Conversion of existing restaurant (A3 Food & Drink) & flat into 2 No. cottages. This application affects the character & appearance of the Felpham Conservation Area.

Ye Old Malt House Restaurant Waterloo Road Felpham

Thank you for your internet representation made on 5th April 2019 which has been recorded as '**an objection**' with the comments as follows:

HERITAGE STATEMENT

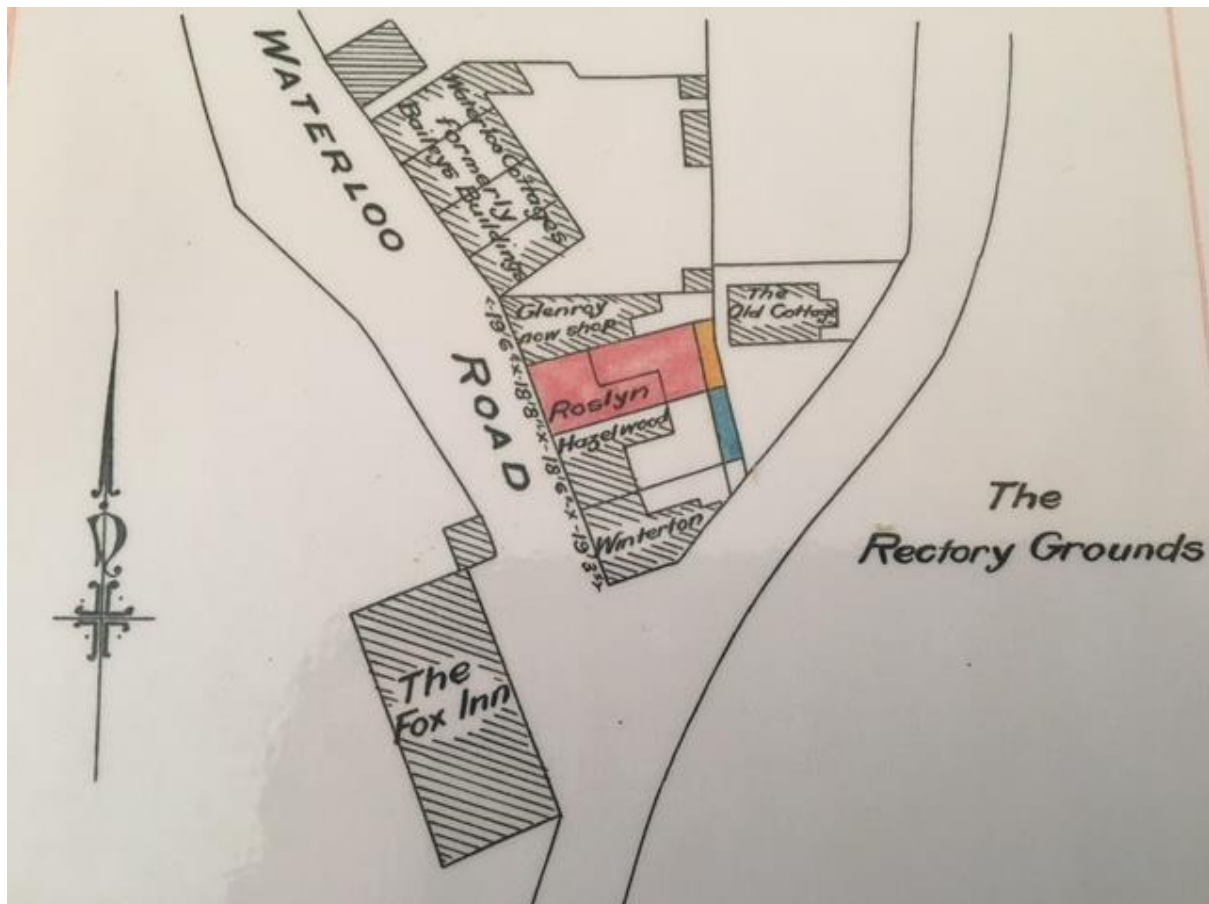
A more comprehensive heritage statement is required. The fenestration needs to be reconsidered and possible should match the adjoining buildings to the south. Total of 4 windows rather than six windows. Modern doors with fixed fan lights are not appropriate to the building or the conservation area and should be replaced with painted 4 panel doors. Proposed ground floor windows could be deeper and the windows need to be sat back such that the reveals match the reveals of the windows on first floor level. If the council are minded to approve the application then a condition on the planning consent is needed to remove permitted development rights given the prominent location within a conservation area.
